Sea Link

Volume 6: Environmental Statement

Document: 6.2.1.6
Part 1 Introduction
Chapter 6
Scoping Opinion and EIA Consultation

Table 6.1 Overarching Planning Inspectorates comments raised in the Scoping Opinion

Document Title: LANDSCAPE CHARACTER - NATIONAL & REGIONAL

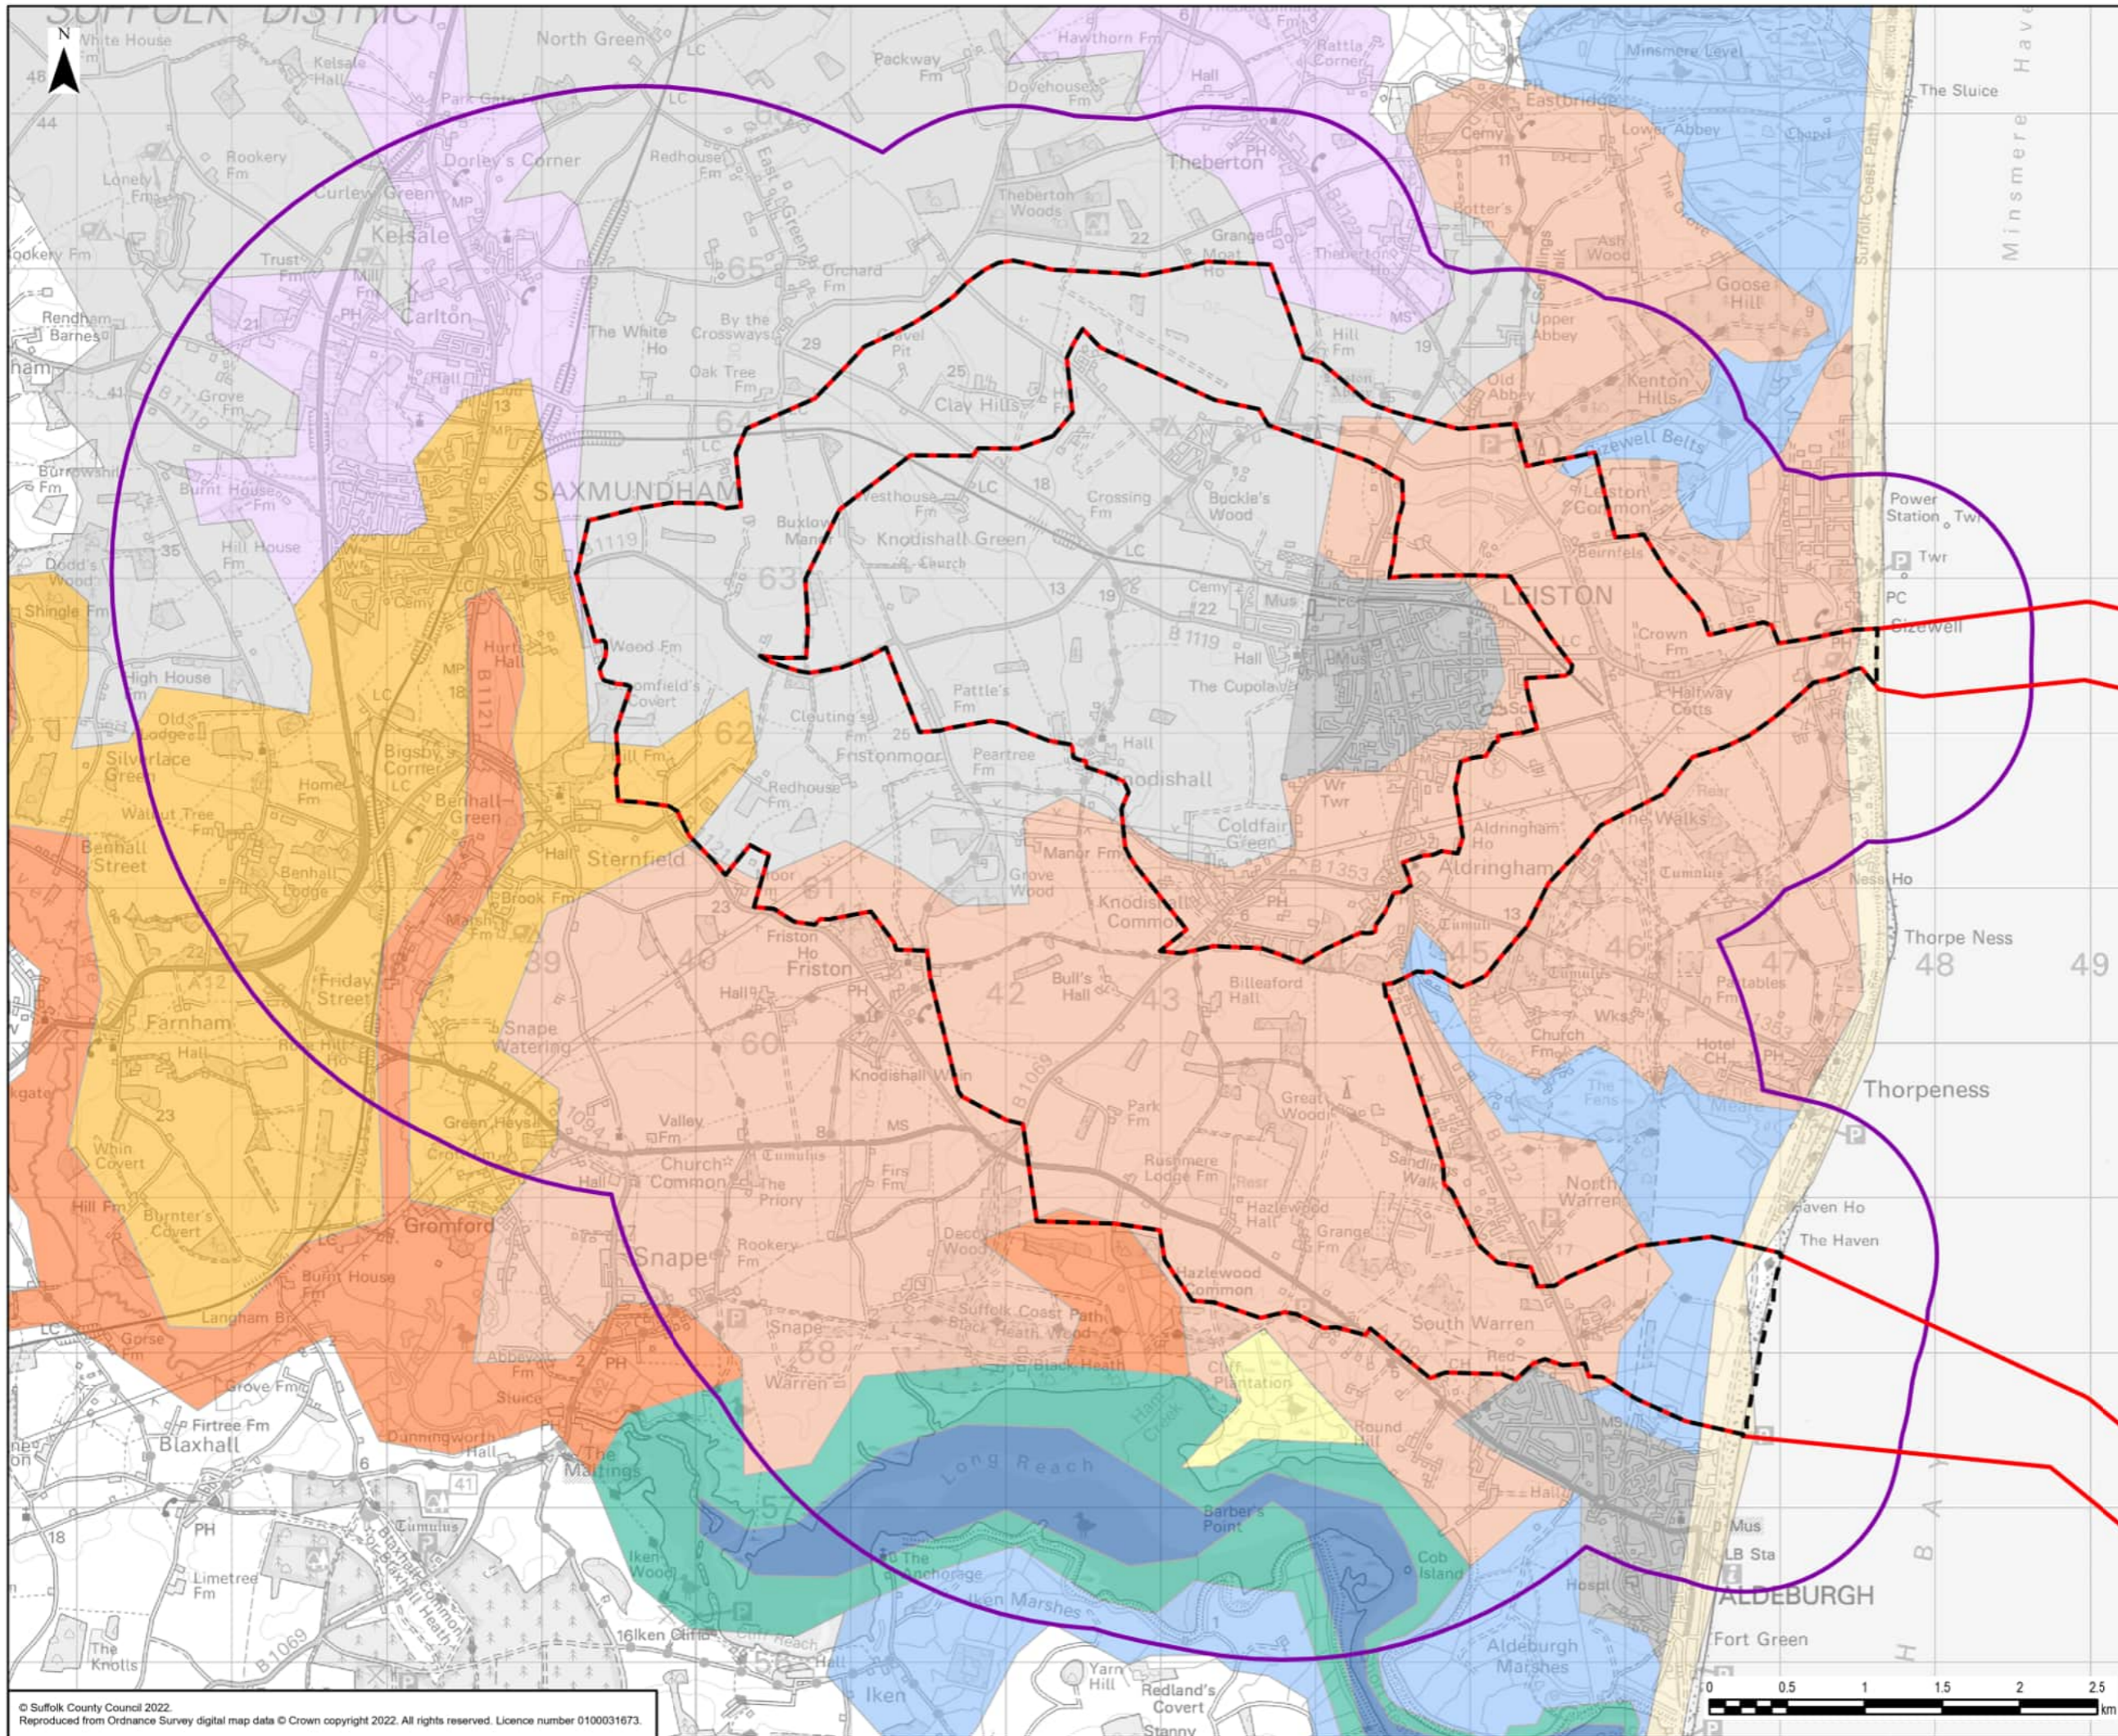
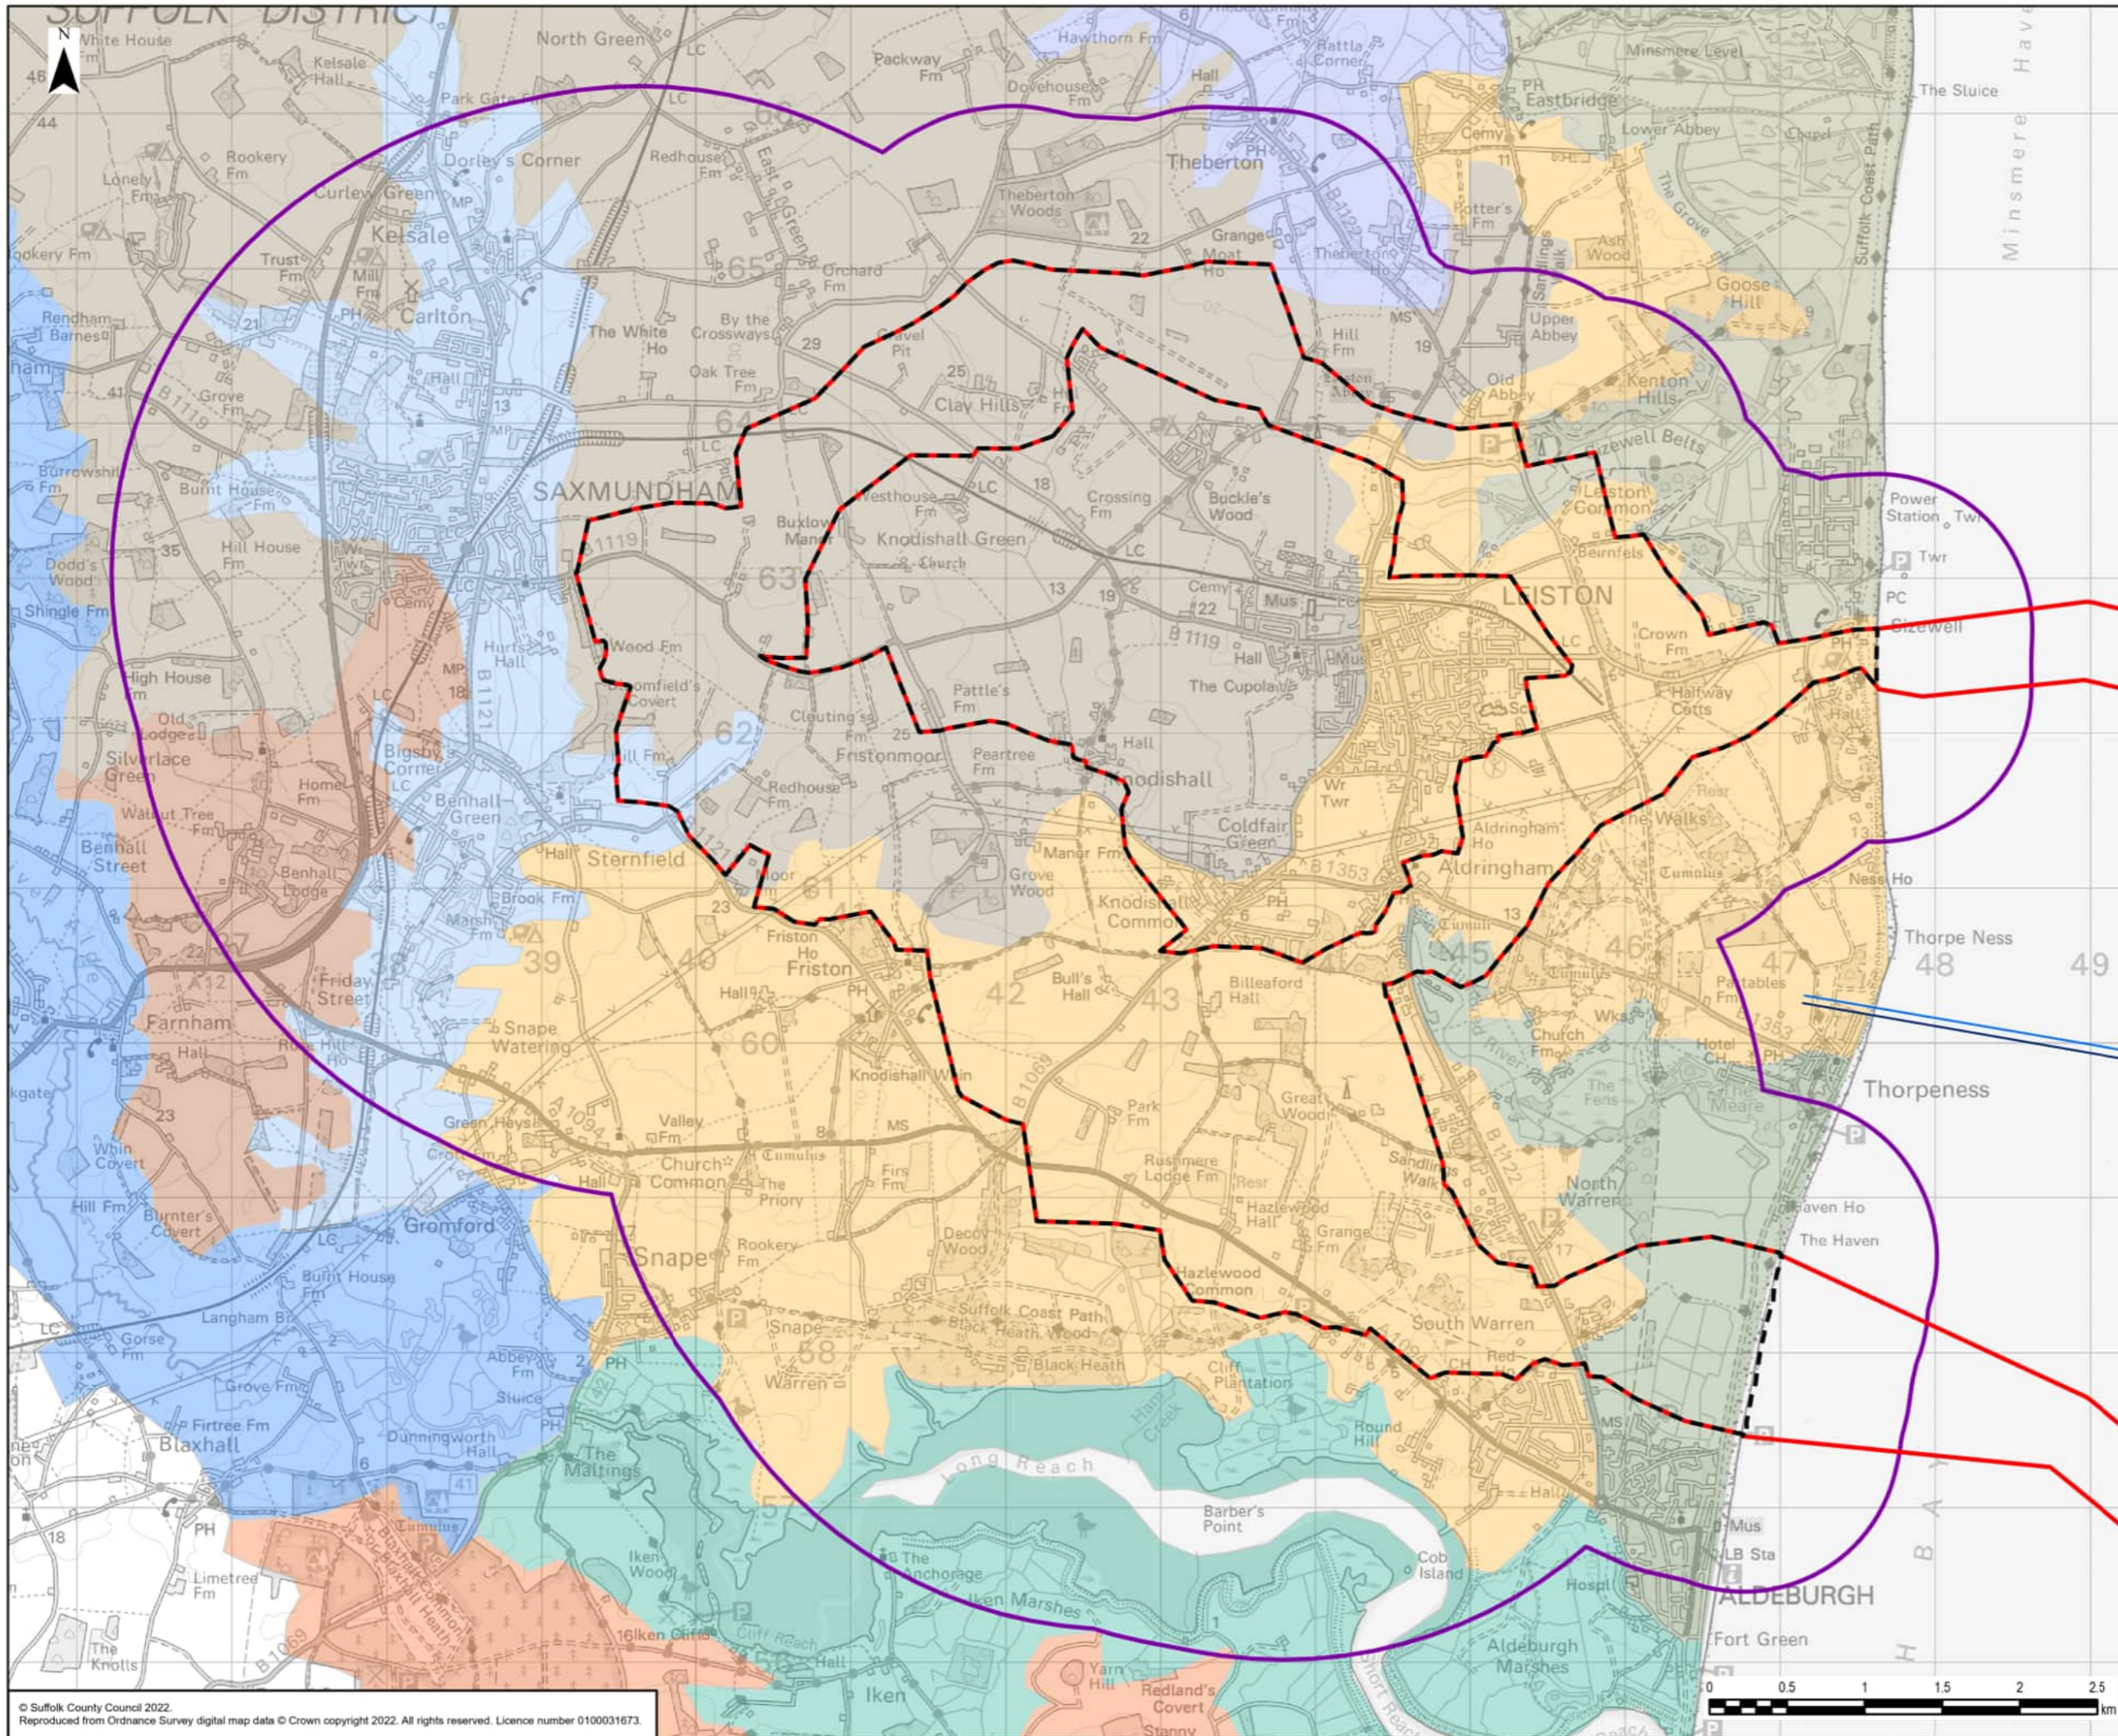
2.2.3	<p>Figures</p> <p>There are a number of Figures where the legends/keys make it difficult to distinguish</p>	<p>Noted, the figures supporting the planning application have considered</p>

varying features. For example, Figure 2.2.3 contains two hatchings of very similar colour, thus making it difficult to distinguish between the regional Landscape Character Types 0 and 16. Figure 2.11.1 is missing the legend/key and the Conservation Areas of Aldeburgh, Thorpeness, Leiston, and Saxmundham are not apparent on Figure 2.4.1, despite being included in the legend/key. The ES should include clearly labelled figures with a clear legend/key to enable interpretation of the information. legibility and have been amended where possible.
